Development Control  
Ribbles Valley Borough Council

**Re: Planning Application 21/0182**

**Address: Whins Lodge Whalley Old Road Langho Lancashire BB6 8DU**

PROJECT NAME		WHINS LODGE	
DRAWING NAME		PROPOSED SITE PLAN	
PROJECT No	STATUS	DATE	
97.20	PLANNING SUBMISSION	JAN 21	
SIZE	SCALE		A1
	1:200		
DRAWING No		06

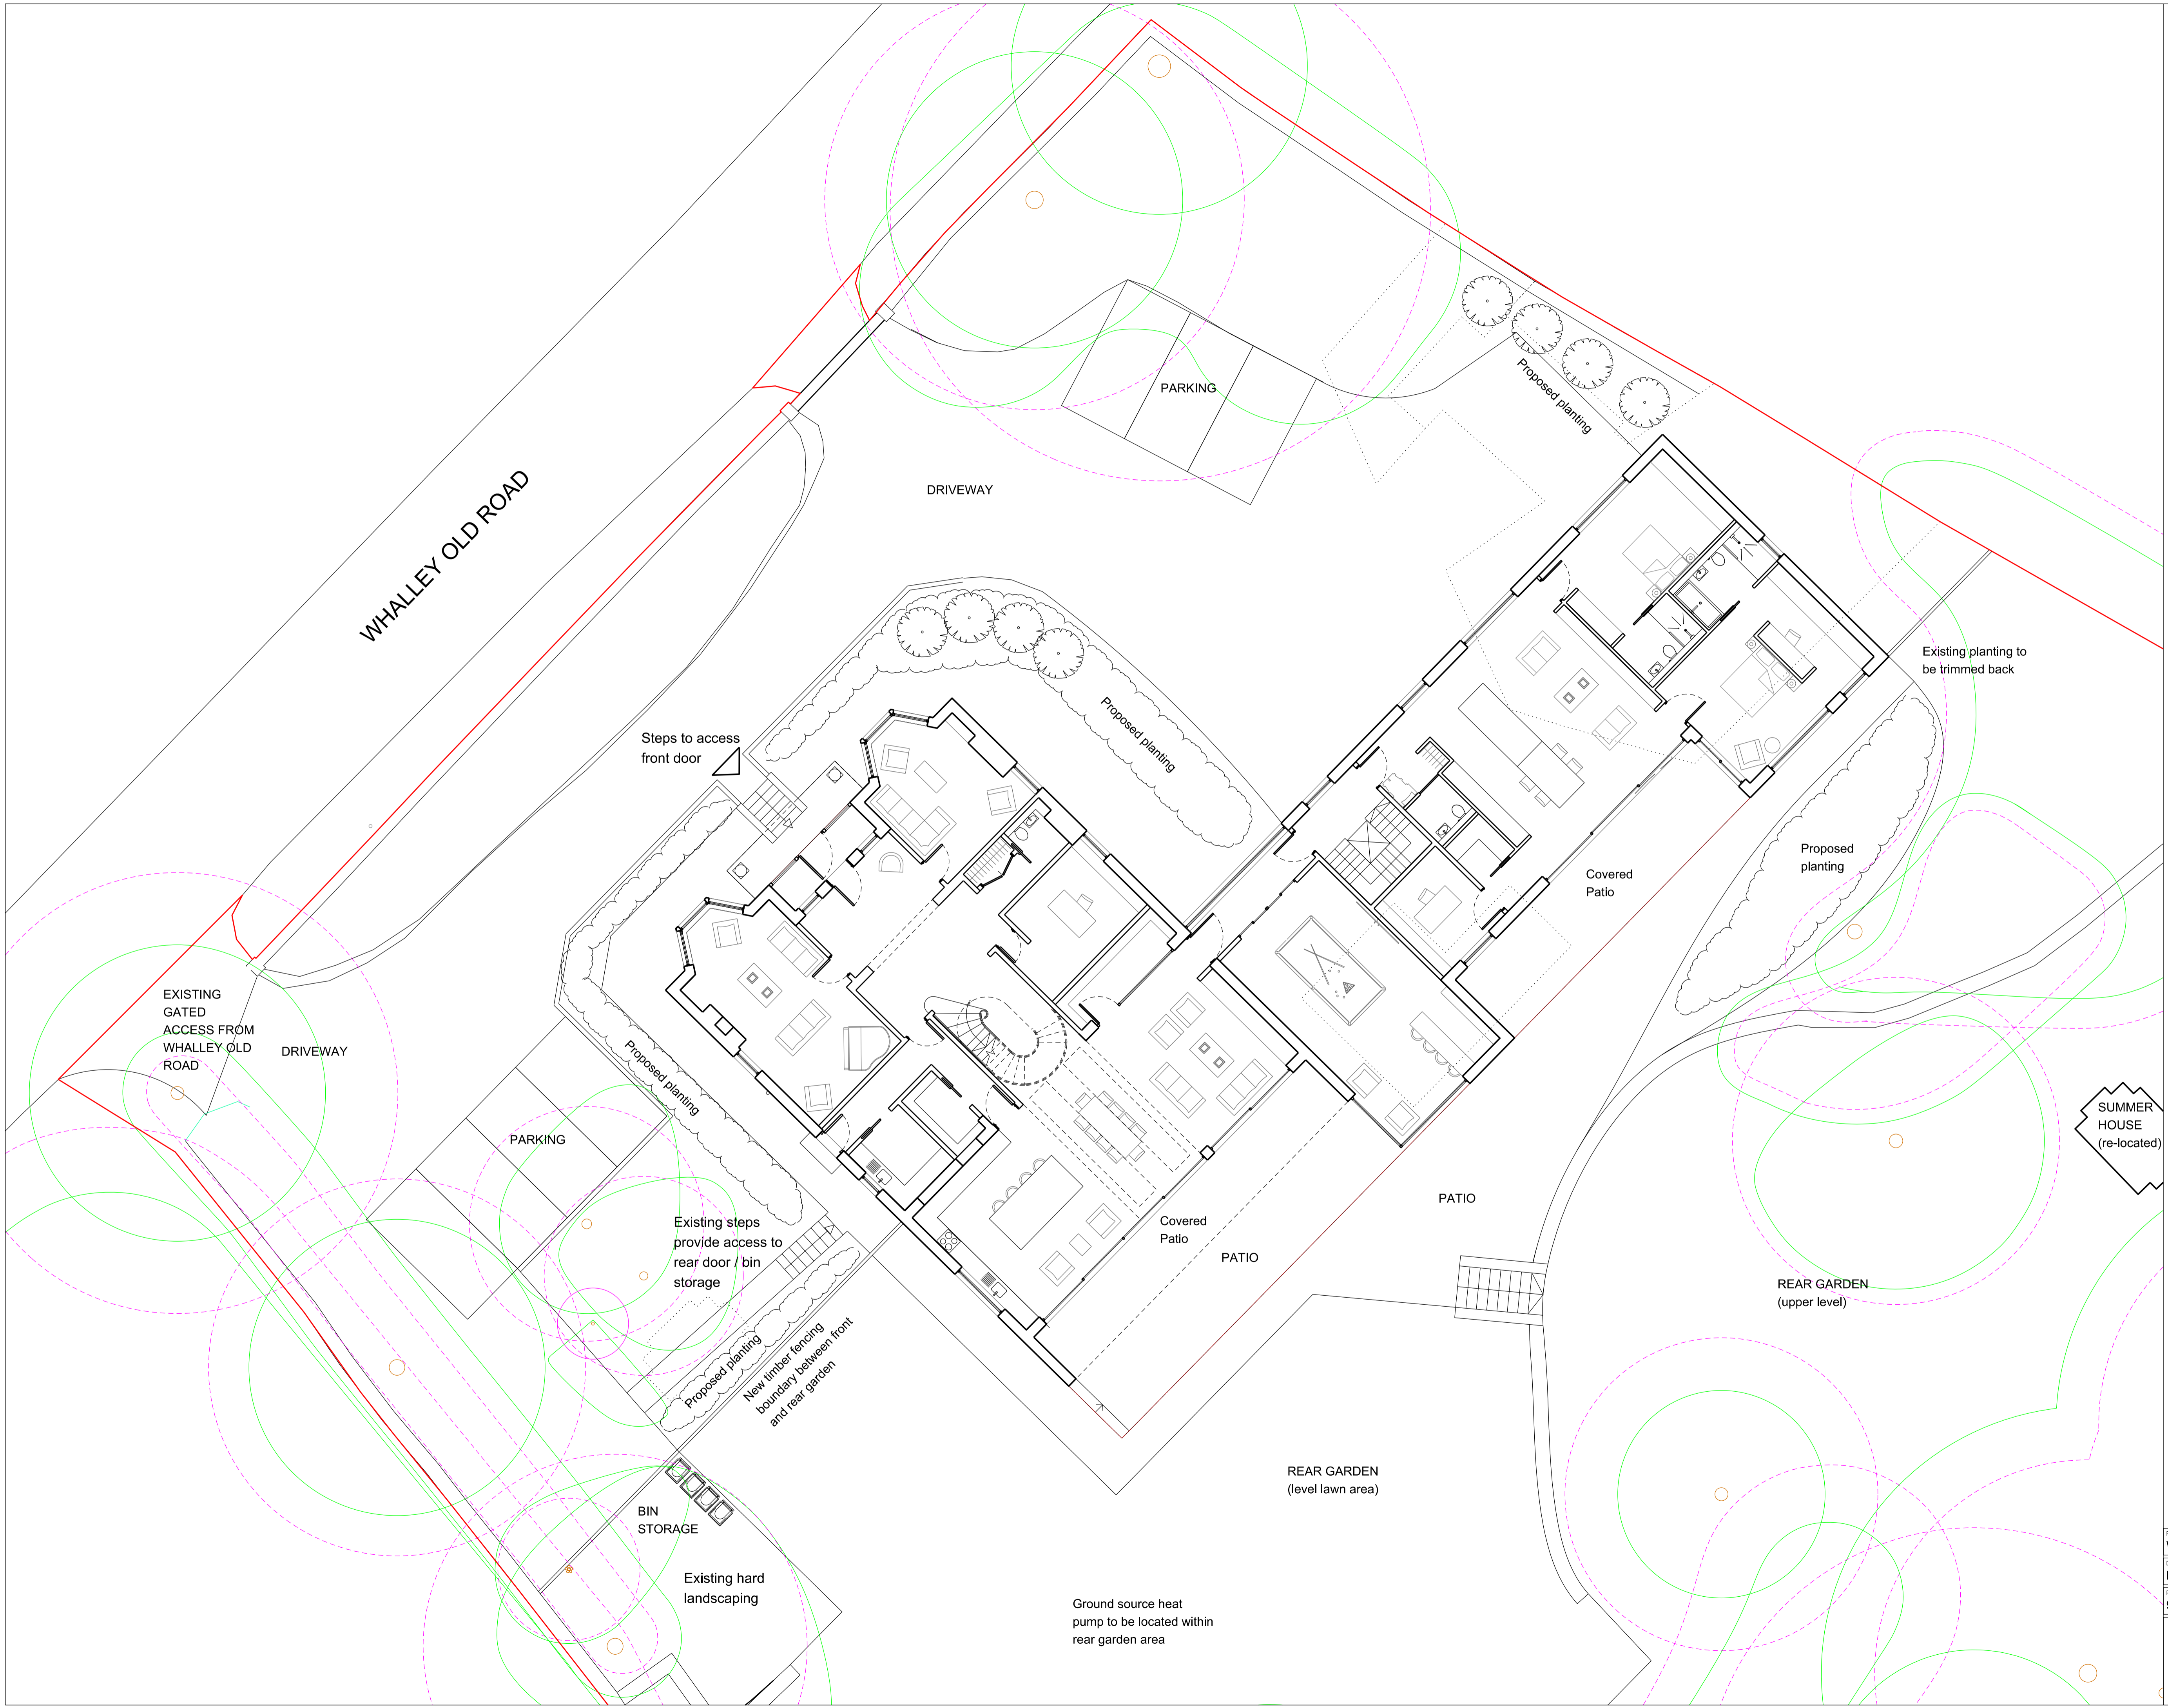
With respect to this application we would not raise any objections to the principle of the application. There are however concerns regarding the access gate and the access to the adopted highway.

In order to allow vehicles to pull clear of the highway the gates should be set back from the edge of the carriageway by at least 5m.

Due to the extensive nature of the application it is expected that a charging point for electric vehicles shall be included with-in the development to promote sustainable modes of transport. This shall be fitted in line with the DfT guidance regarding Electric Vehicle Charging in Residential and Non-residential buildings, which states :- charge points must have a minimum power rating output of 7kW, be fitted with a universal socket that can charge all types of electric vehicle.

Before the access is used for vehicular purposes, any gateposts erected at the access shall be positioned 5m behind the nearside edge of the highway and visibility splay fences or walls shall be erected from the gateposts to the existing highway boundary, such splays shall be 45° to the centre line of the access. The gates shall open away from the highway. Should the access remain un-gated 45° splays shall be provided between the highway boundary and points on either side of the drive measured 5m back from the nearside edge of the highway.

Before the access is used for vehicular purposes, that part of the access extending from the highway boundary for a minimum distance of 5m into the site shall be appropriately paved in tarmac, concrete, block pavements, or other hard material to be approved by the Local Planning Authority.

All garage facilities on off street parking shall include provision of an electrical supply suitable for charging an electric motor vehicle.
